DEPARTMENT OF PARKS AND COMMUNITY SERVICES

February 22, 2024

Subject: The Estates at Cathedral Pines Final Plat (SF2234)

PCD FILE # SF2234
JOB NO. 25260.00
JUNE 12, 2024
SHEET 3 OF 3

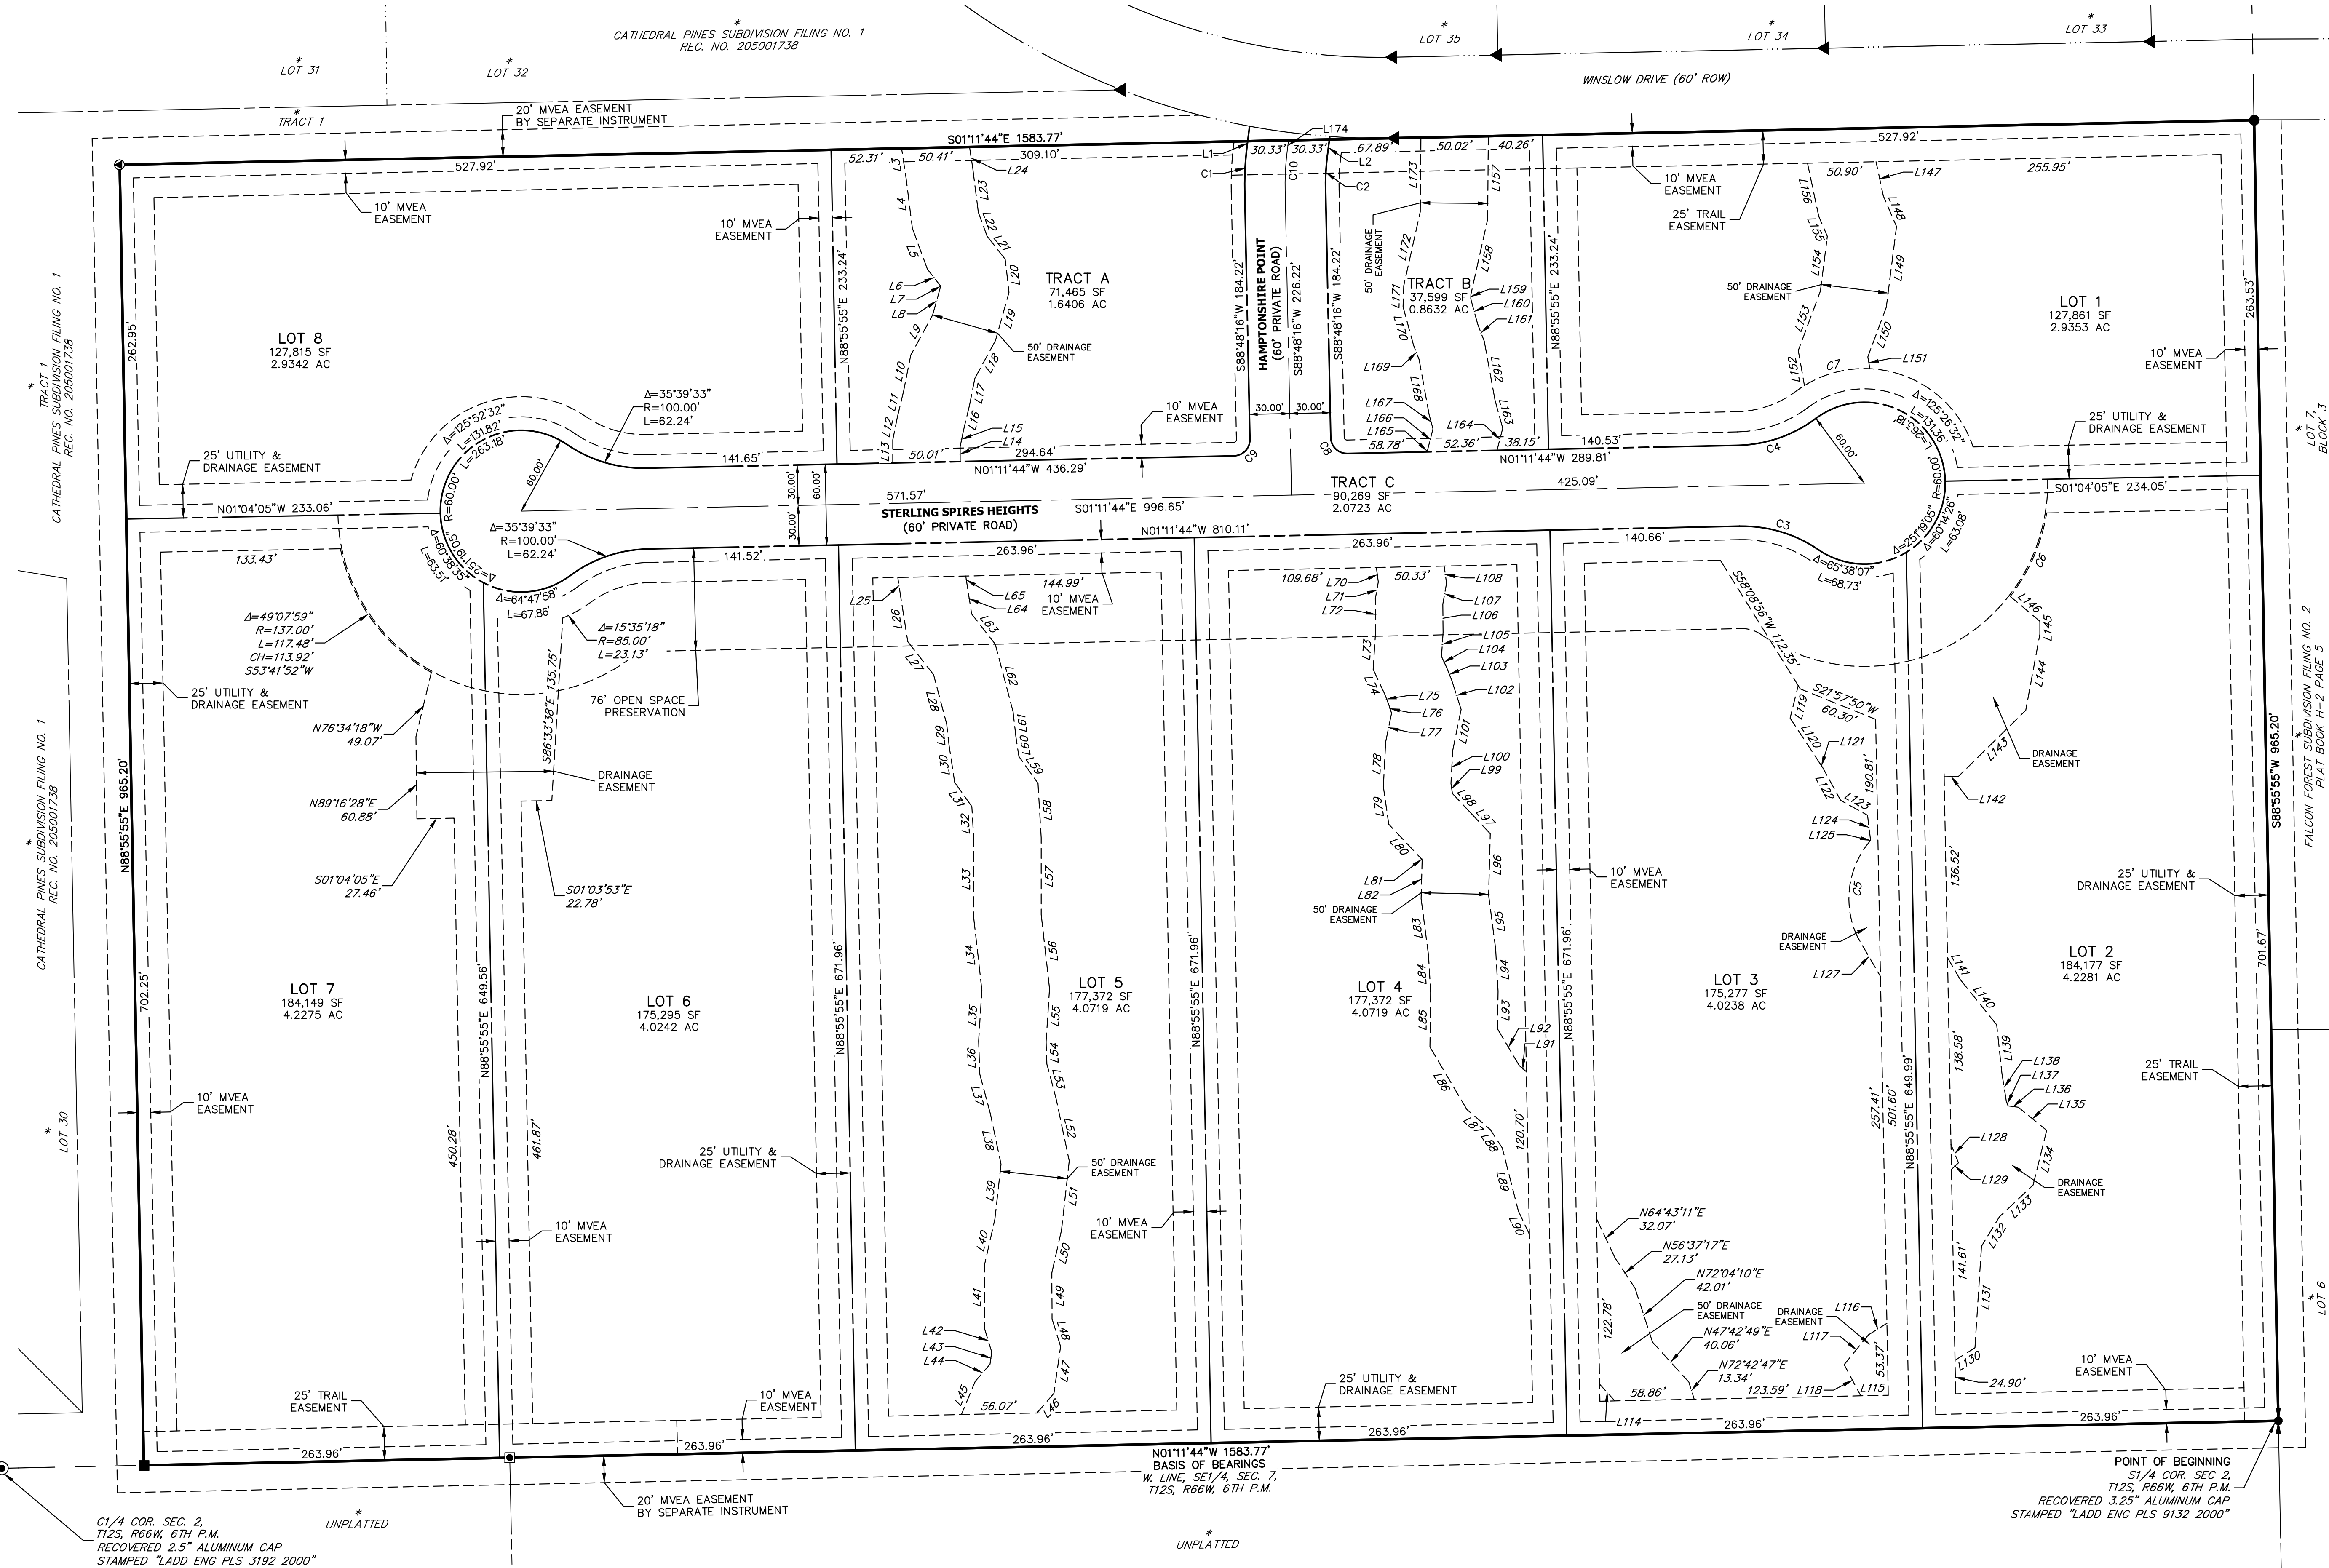
Being zoned PUD, the applicant is required to provide 10% open space dedications or 3.5 acres. Currently, the open space dedications are not clearly being shown on the final plat. The final plat includes two tracts along Winslow Drive totaling 2.5 acres, and the inclusion of several "open space preservation areas" on the individual residential lots. However, there are no open space area calculations or plat notes stating these areas are to be preserved.

The Land Development Code (LDC 4.2.6.F.8.c) allows an applicant to include open space areas on private residential lots and include them in the open space calculations if they are subject to open space easements and restrictions. This would provide assurances that there would be no stormwater, roads, or the placement of structures within these areas typical with open space dedications. The Final Plat needs to include open space / preservation area calculations and plat notes.

Because there are no open space calculations, it is not feasible to calculate if the required 10% open space is being provided for PUD zoning. Additionally, the two open space tracts also include stormwater infrastructure which is only allowed if it comprises less than 10% of the required open space. Overall, the final plat lacks sufficient detail and information to determine if the applicant is providing the required 10% open space dedication required for PUD zoning.

1. Designate and provide to El Paso County a 25-foot trail easement, north-south along the eastern boundary of Lot 1 and Lot 8 to connect the existing county trail along Winslow Drive.
2. Designate and provide to El Paso County a 25-foot trail easement, north-south along the western boundary of Lot 6 and 7 for the Palmer Divide Regional Trail.
3. Designate and provide to El Paso County a 25-foot trail easement, east-west along the southern boundary of Lot 1 and Lot 2 for the Palmer Divide Regional Trail.

The Park Advisory Board recommends that the Planning Commission and the Board of County Commissioners include the following conditions when considering and/or approving The Estates at Cathedral Pines Final Plat: (1) Provide open space dedications of 10% consistent with PUD zoning, show them as tracts or conservation areas, and include the appropriate plat note and land use table on the final plat drawings (2) show on the final plat and dedicate to El Paso County a 25-foot trail easement, north-south along the eastern boundary of Lot 1 and Lot 8 to connect the existing county

trail along Winslow Drive; (3) show on the final plat and dedicate to El Paso County a 25-foot trail easement, north-south along the western boundary of Lot 6 and Lot 7 for the Palmer Divide Regional Trail; (4) show on the final plat and dedicate to El Paso County a 25-foot trail easement, east-west along the southern boundary of Lot 1 and Lot 2 for the Palmer Divide Regional Trail; (5) the trail easements shall be shown on the final plat and allow for public access, as well as construction and maintenance by El Paso County; (6) revise the construction and grading plans to include a trail crossing across Windermere Court; (7) require fees in lieu of land dedication for regional park purposes in the amount of \$3,680 will be due at recording of the final plat.
